From: [REDACTED]
To: [Hinckley SRFI](#)
Subject: Hinckley RNFI - Objection
Date: 03 February 2025 10:35:54

Following on from the latest amendment to the proposal please see below as to why I strongly object and feel that critical details have been overlooked.

Appendix A Part 3 - Vehicle Tracking Sheet 2

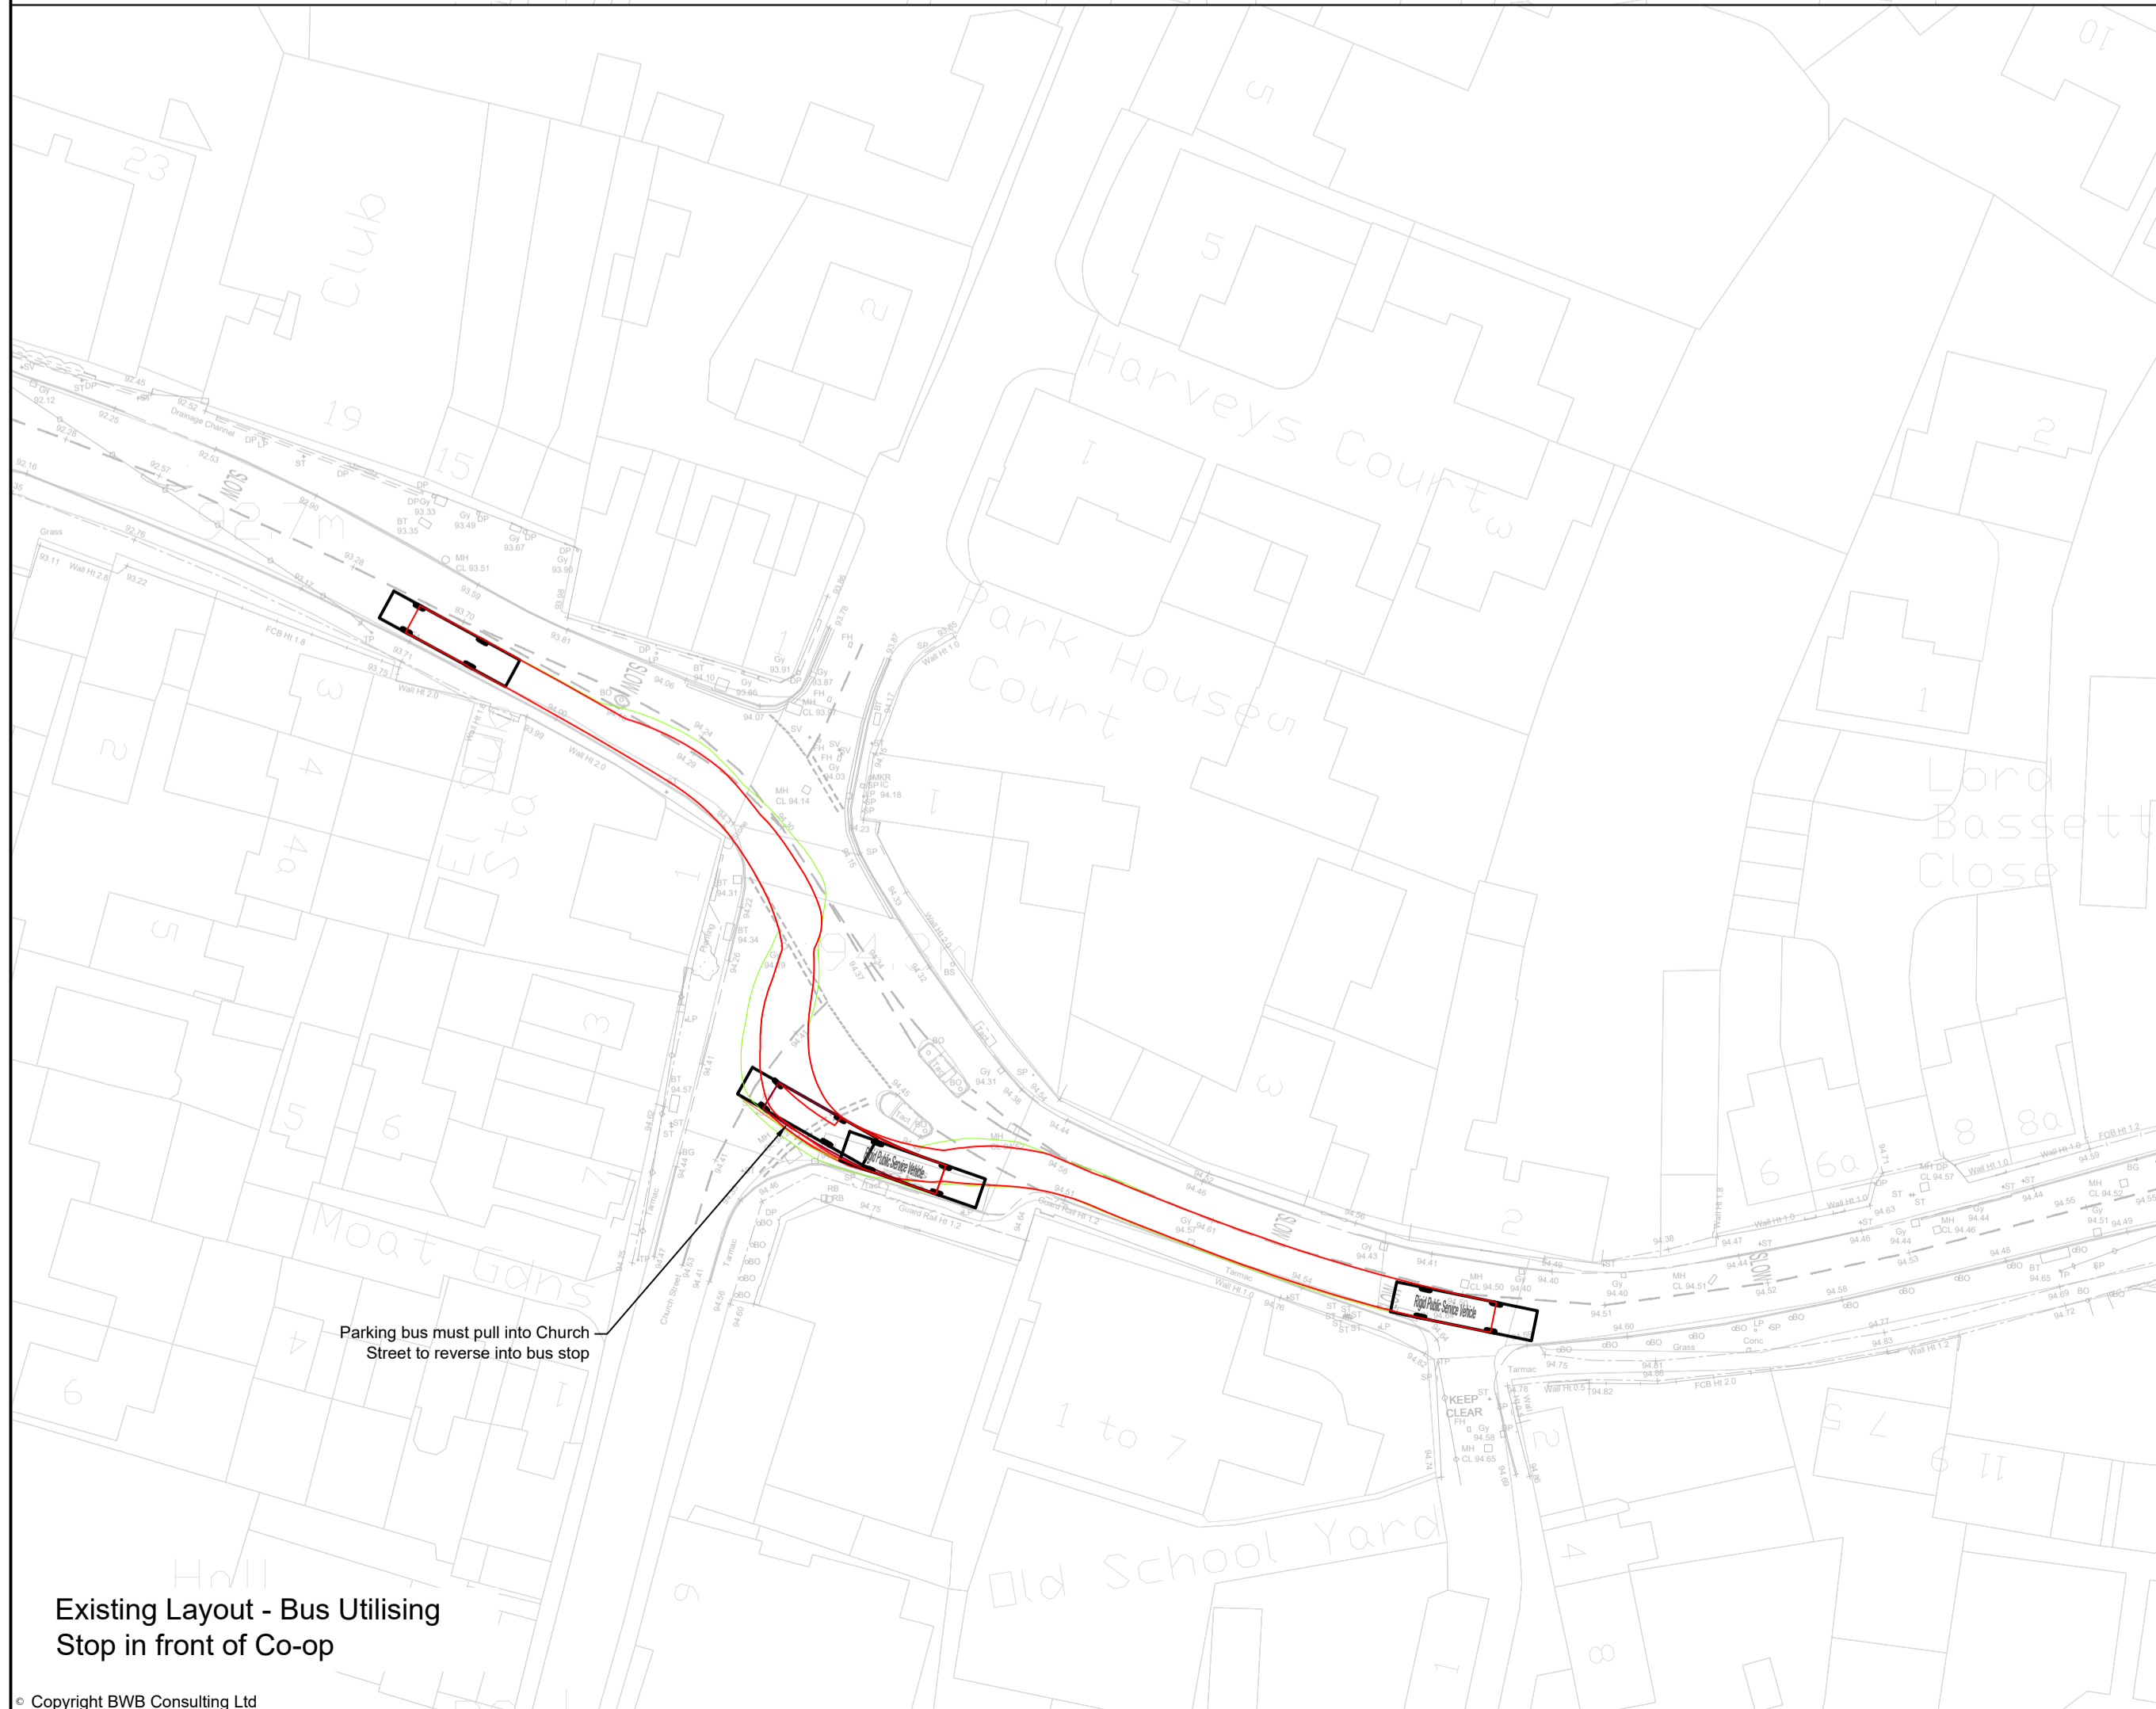
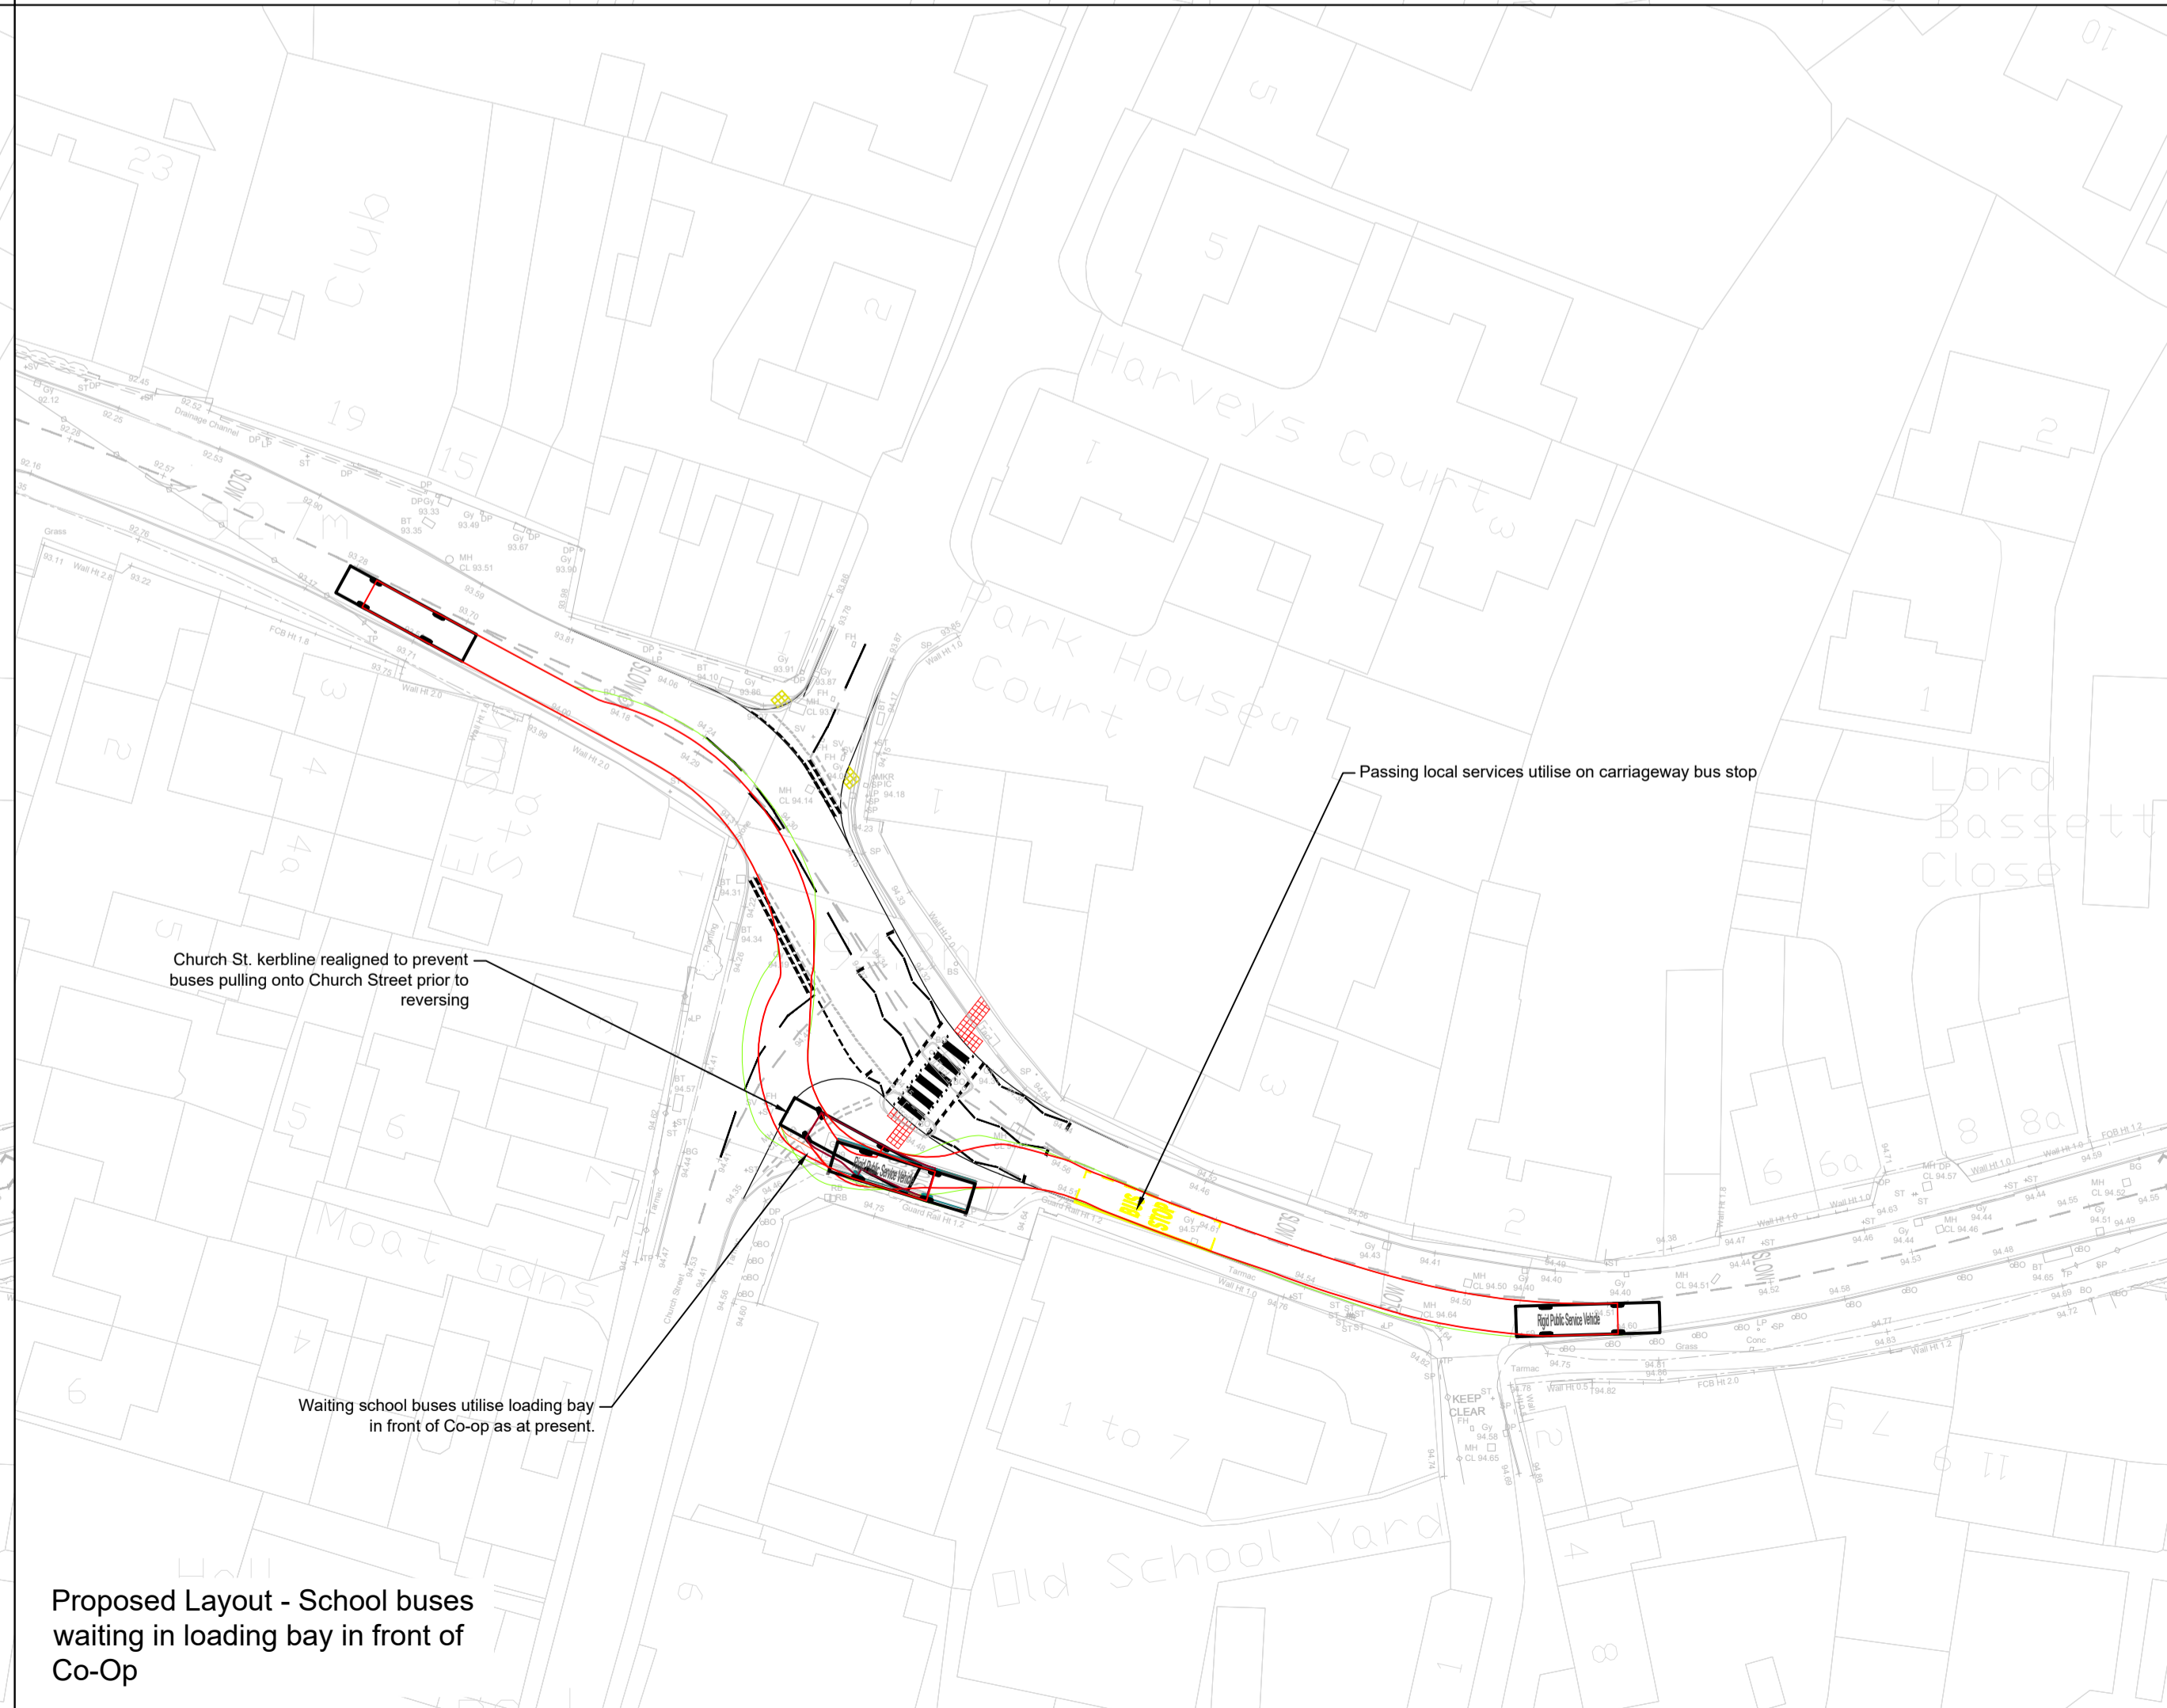
Pedestrianising the current bus stop outside the Co-op. This would cause an enormous amount of congestion on the suggested narrow road. There is limited coop parking, forcing vehicles either attending the Co-op or the cash machine will be forced to park in other areas. This will undoubtedly cause more congestion and hazards. The crossing here is where many school children cross to get to the primary school. I fear that trying to cross here on the new proposal will just mean that Primary aged children are having to take their life into their own hands, dodging traffic, trying to cross in between parked vehicles, and then being pinned up against walls by HGVs cutting the bend. Furthermore this is a bus stop and a school bus stop pick up point. Whilst children's safety is a huge concern to me, I also fear for the elderly trying to access services on either side of the proposed HGV corridor.
